Consultation Response from KC, Highways Development Management
2026/91615 Land off, Roslyn Avenue, Netherton, Huddersfield, HD4 7EW
Discharge of details reserved by Conditions 14 (Phasing Plan), 15 (Construction Ecological Management Plan (CEMP)), 16 (Construction Environmental Management Plan: Biodiversity), 17 (Phase 2 Investigation), 18 (Remediation Strategy), 19 (unexpected contamination), 20 (verification), 21 (Surface water drainage scheme), 22 (Flood routeing), 23 (temporary surface water), 24 (Arboricultural method statement), 25 (road condition survey), 26 (highway structures), 27 (retaining wall spec), 28 (Written Scheme of Archaeological Investigation (WSI)), 29 (Ecological Design Strategy (EDS)), 30 (PROW HUD/228/10 improvement spec), 31 (road, footway, and footpath spec), 32 (site access spec), 33 (internal estate streets spec), 34 (Local Equipped Area of Play (LEAP) spec), 35 (Travel Plan), 36 (Cycle store details), 37 (ancient woodland information boards spec), and 38 (ancient woodland information packs spec) on previous permission 2025/91870 for variation of conditions 5 (plans and specifications), 29 (Ecological Design Strategy), 32 (site access works and road mark

drawing title:
 Section 38 Layout Plan

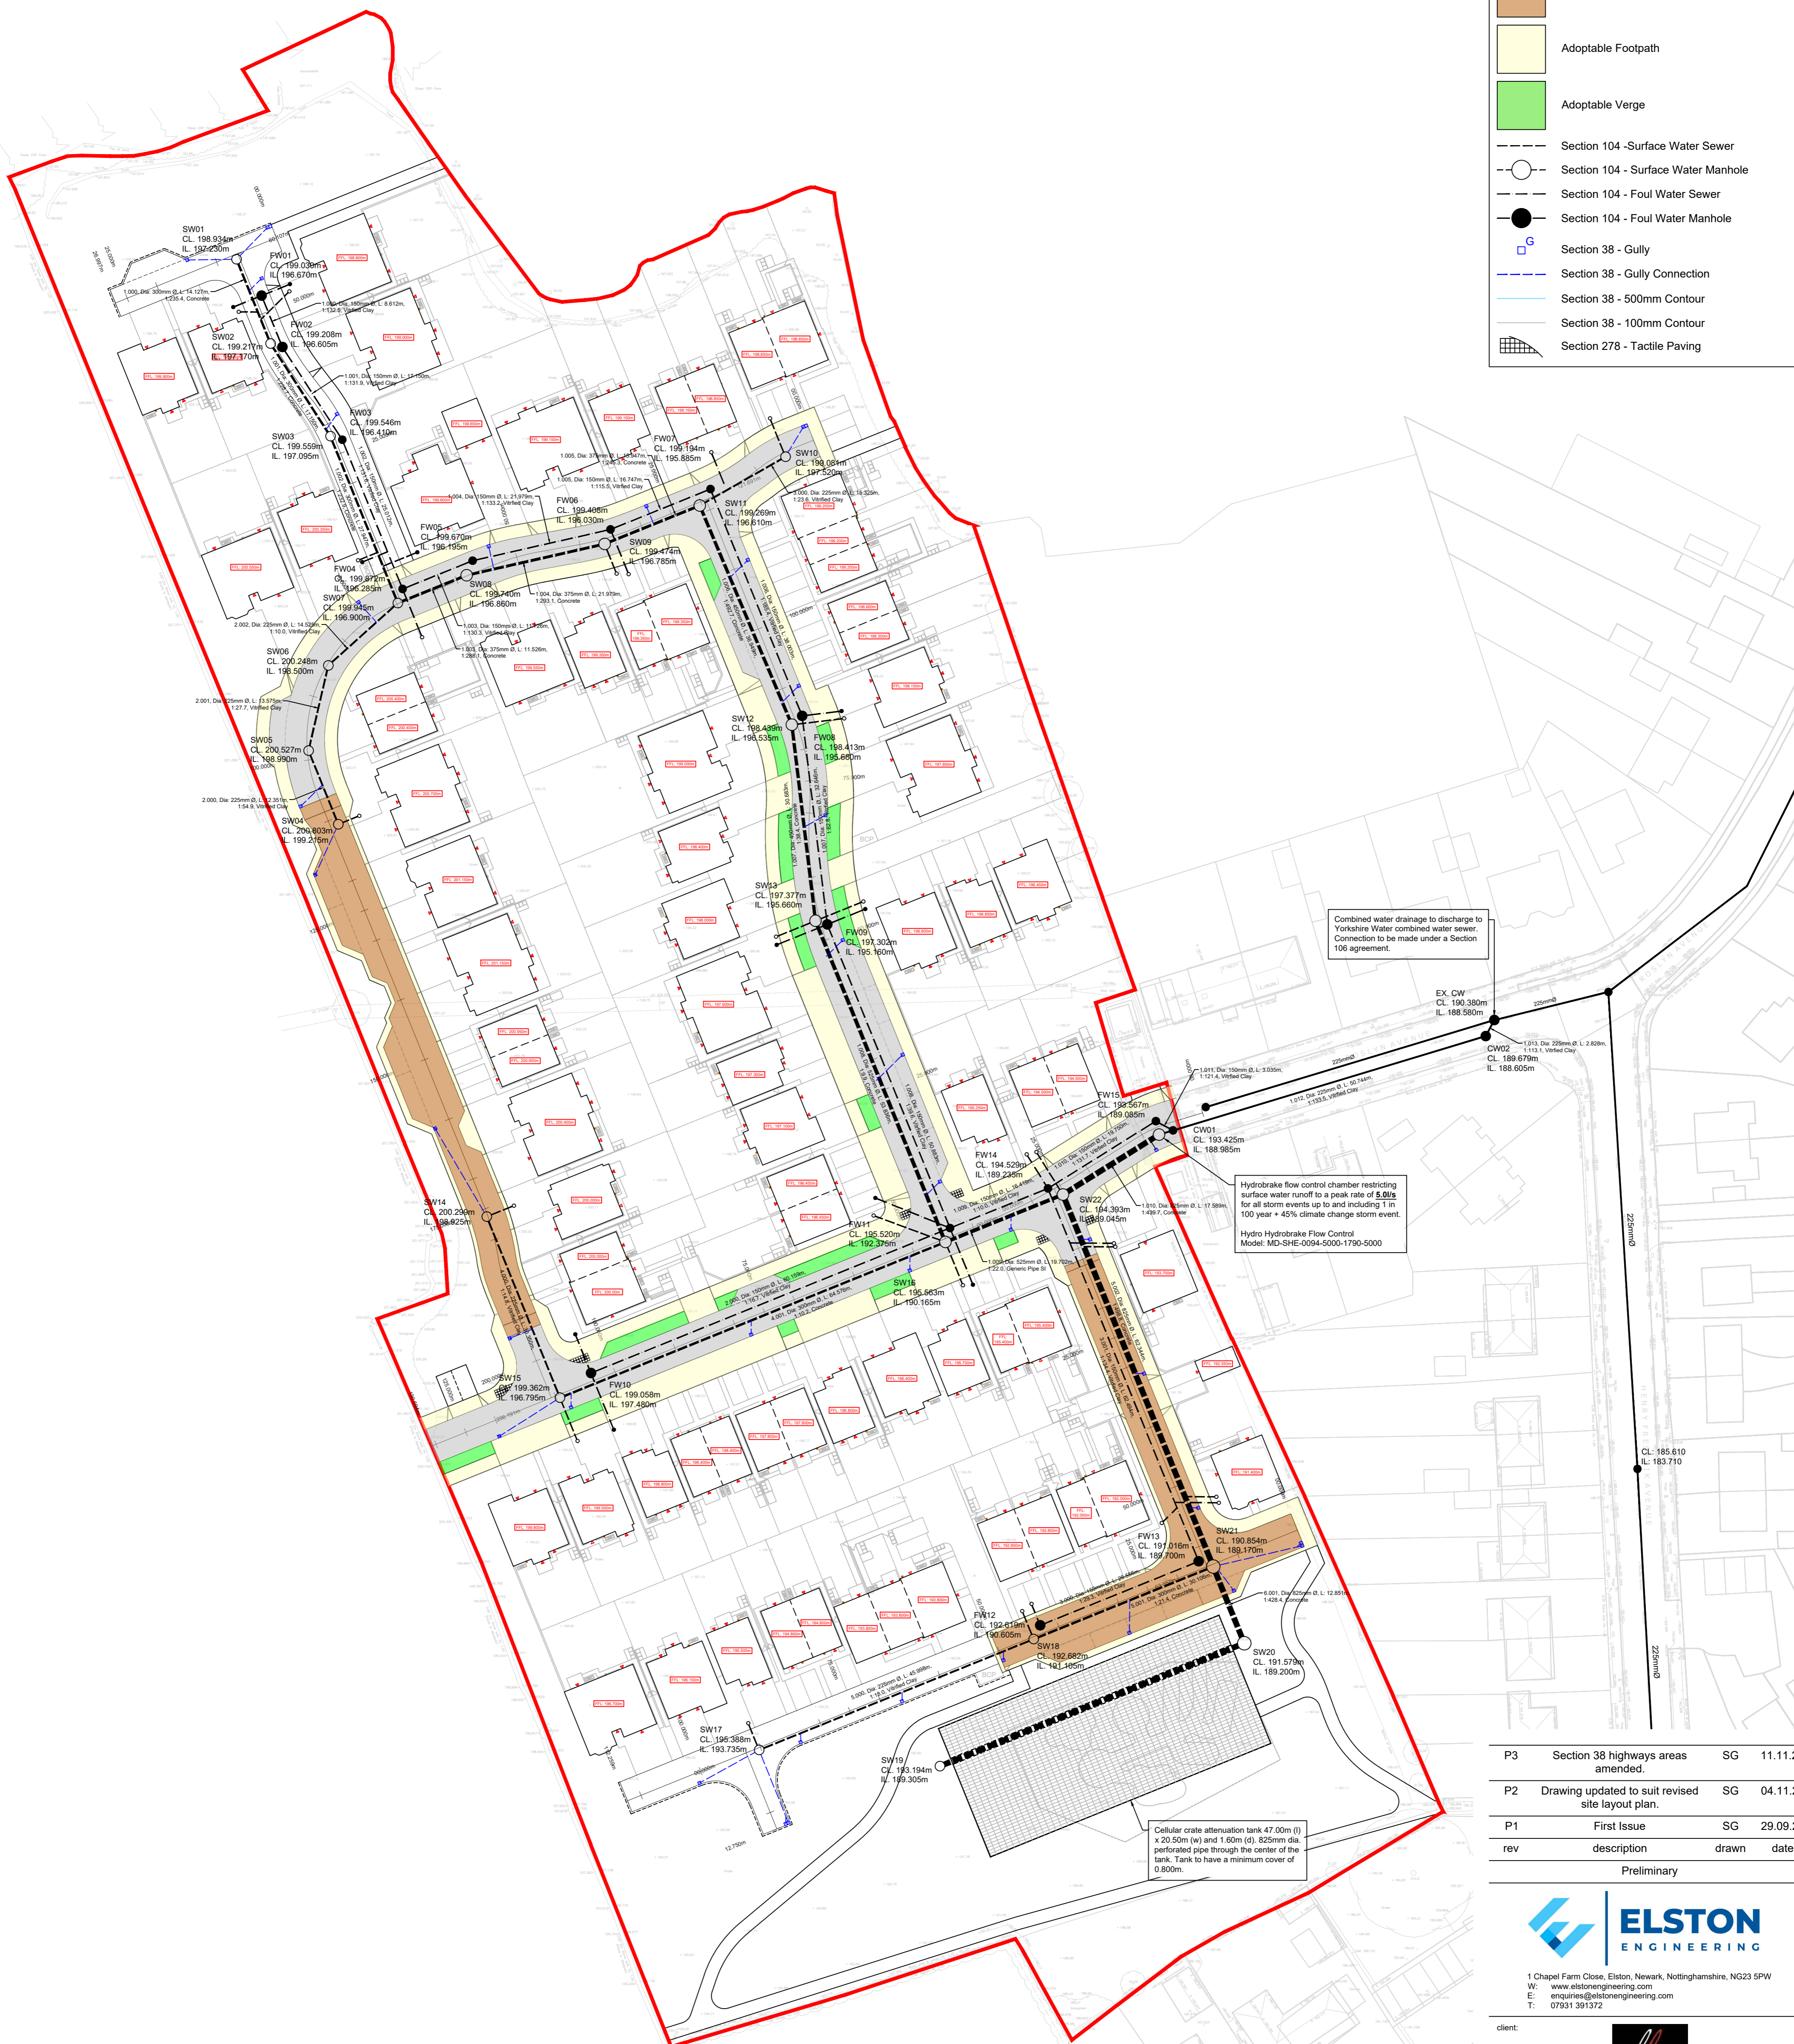
A package of highway engineering drawings has been submitted. This includes a Proposed Highways Plan (Drawing Ref: EE100008 301) and Highways Area Plan (Drawing Ref: EE100008-306), together with a Section 38 Layout Plan (Drawing Ref: EE100008-200), kerbing and surfacing layout drawings (Drawing Refs: EE100008-205, EE100008-206 and EE100008-207), longitudinal sections (Drawing Ref: EE100008-216, Sheets P2–P4), Section 38 construction details (Drawing Refs: EE100008-218, EE100008-219 and EE100008-220), swept paths and visibility splays.

drawing title:  
Proposed Highways Plan

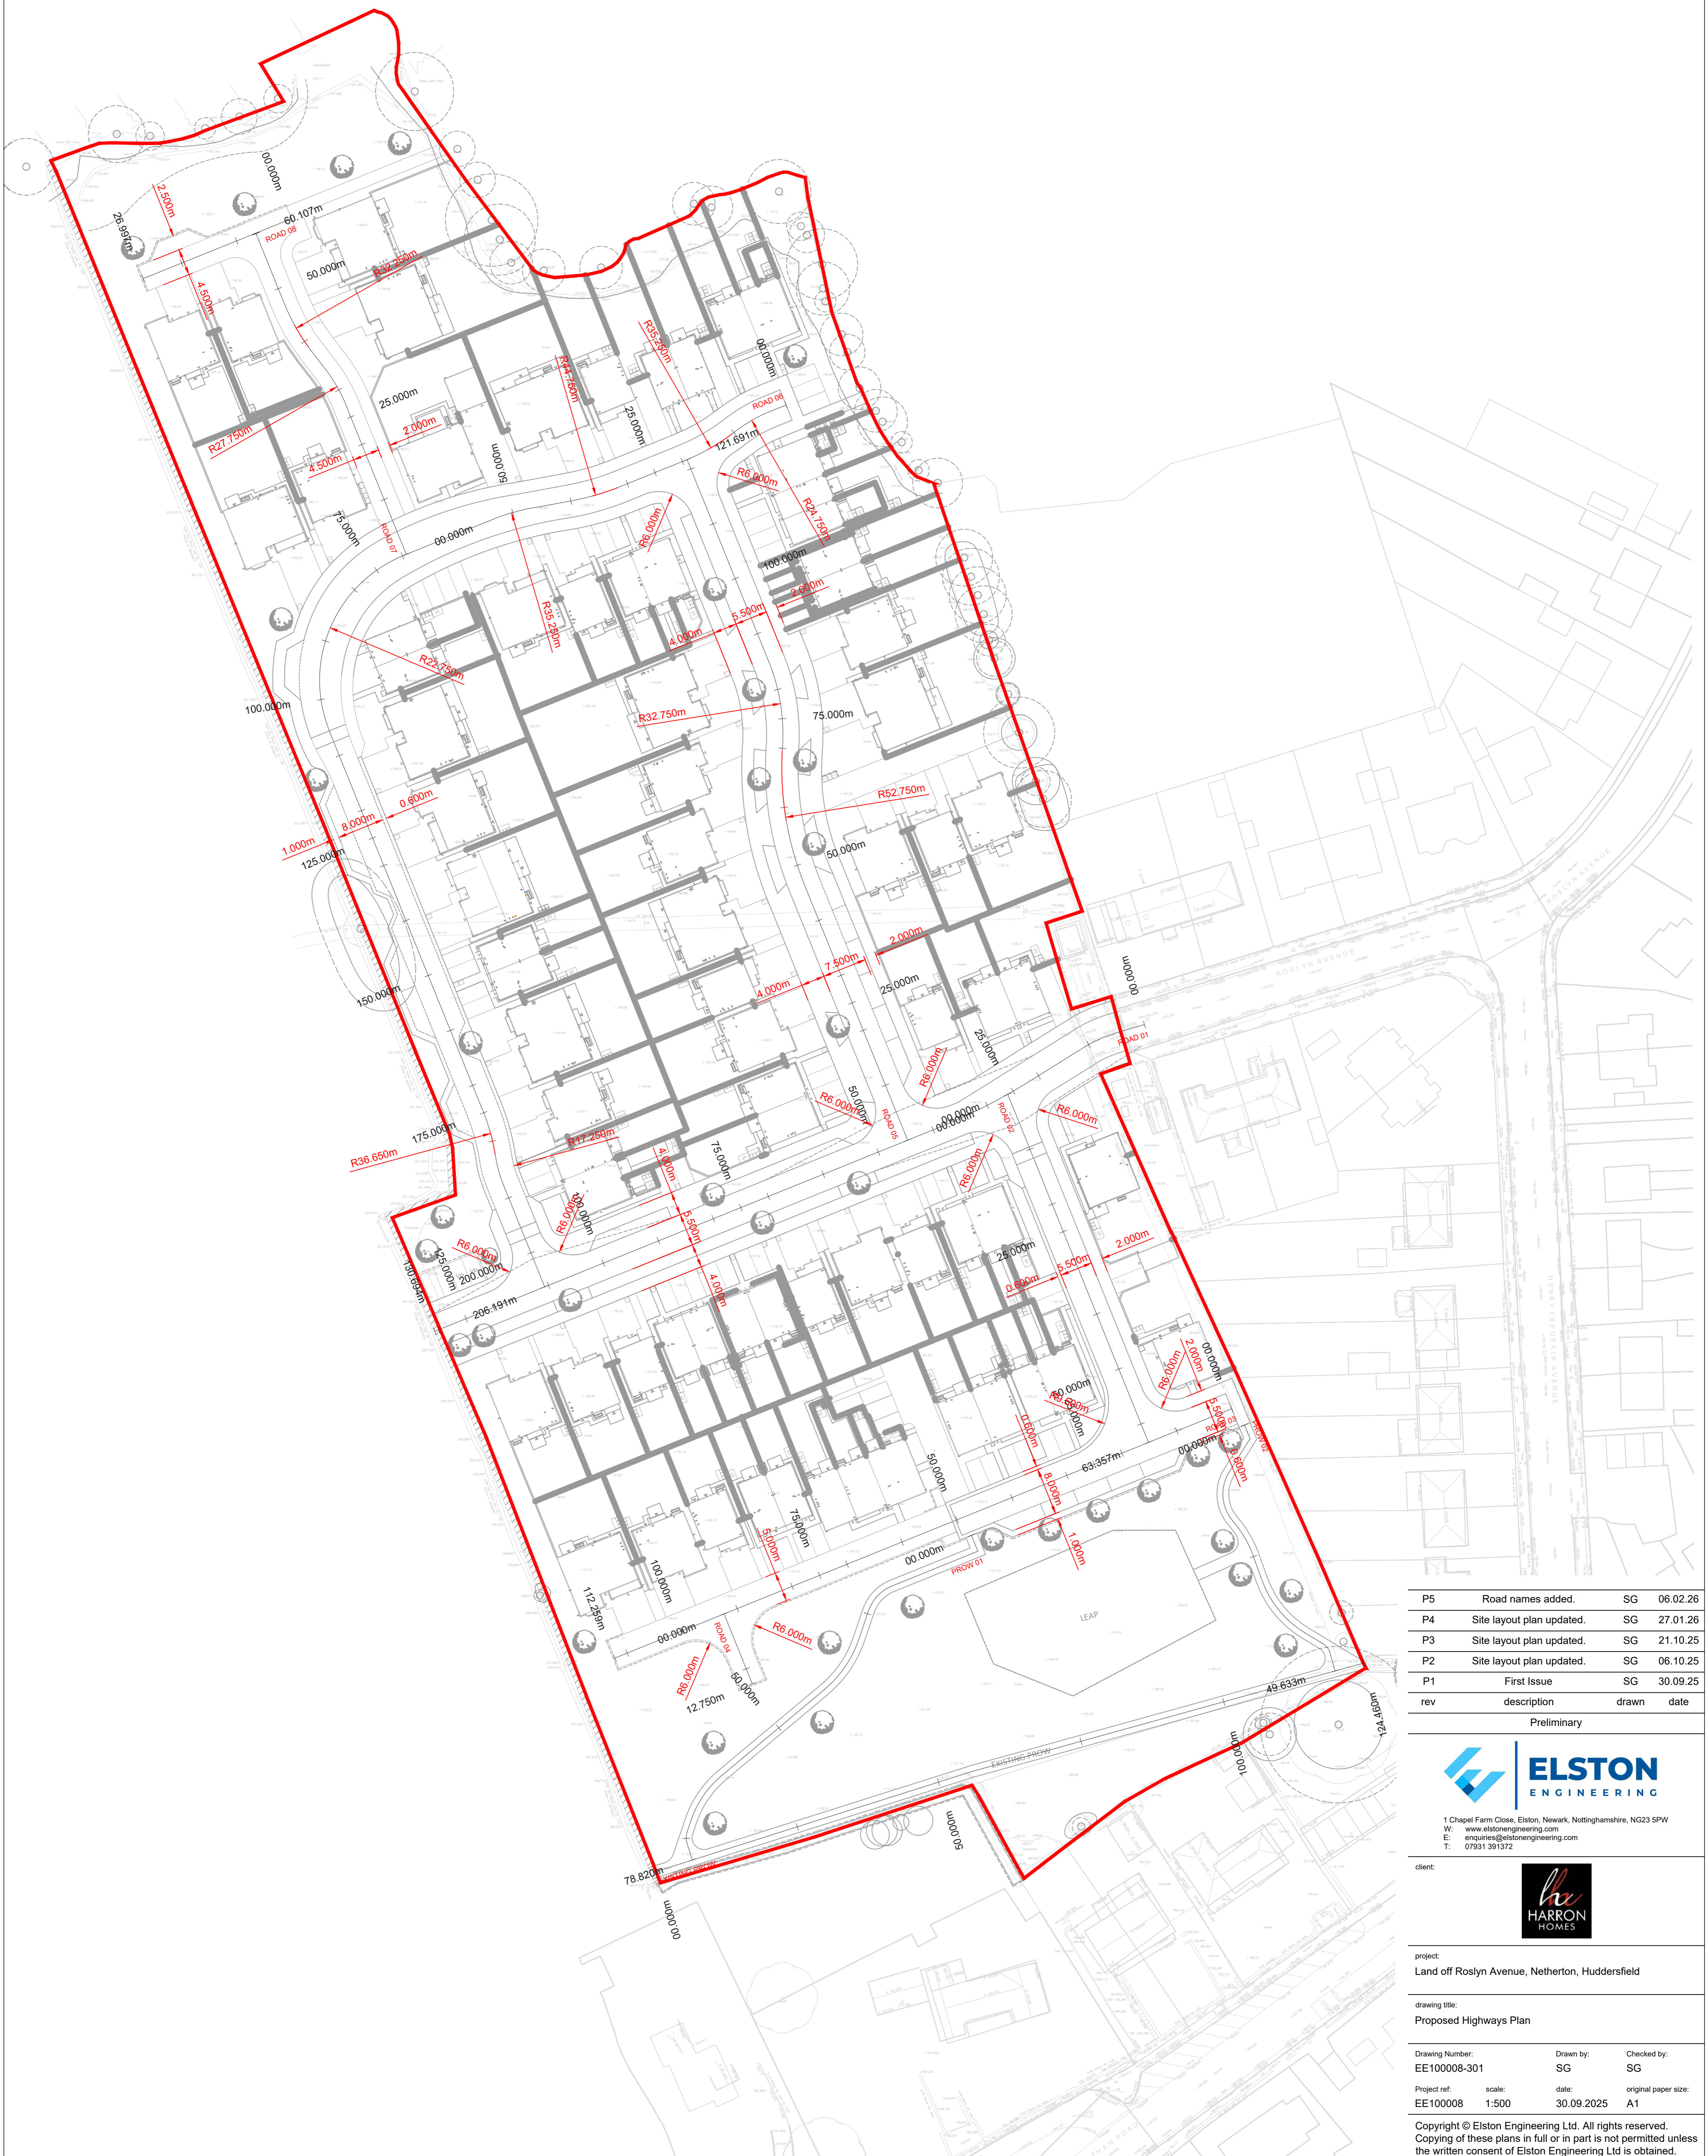
Confirmation is awaited from the Highway Agreements team and further comments will be separately provided, on the officer's return from leave. Notwithstanding, the EE100008-306 P1 - Highways Area Plan and EE100008-301 P5 - Proposed Highways Plan are not in accordance with the approved revisions under 2025/92541 which is 306 rev P3 and 301 rev P7. These should correspond or be a later version and must be resubmitted. Several other drawings are incorrectly labelled on the portal including those relating to swept paths and visibility splays and should be amended for clarity.
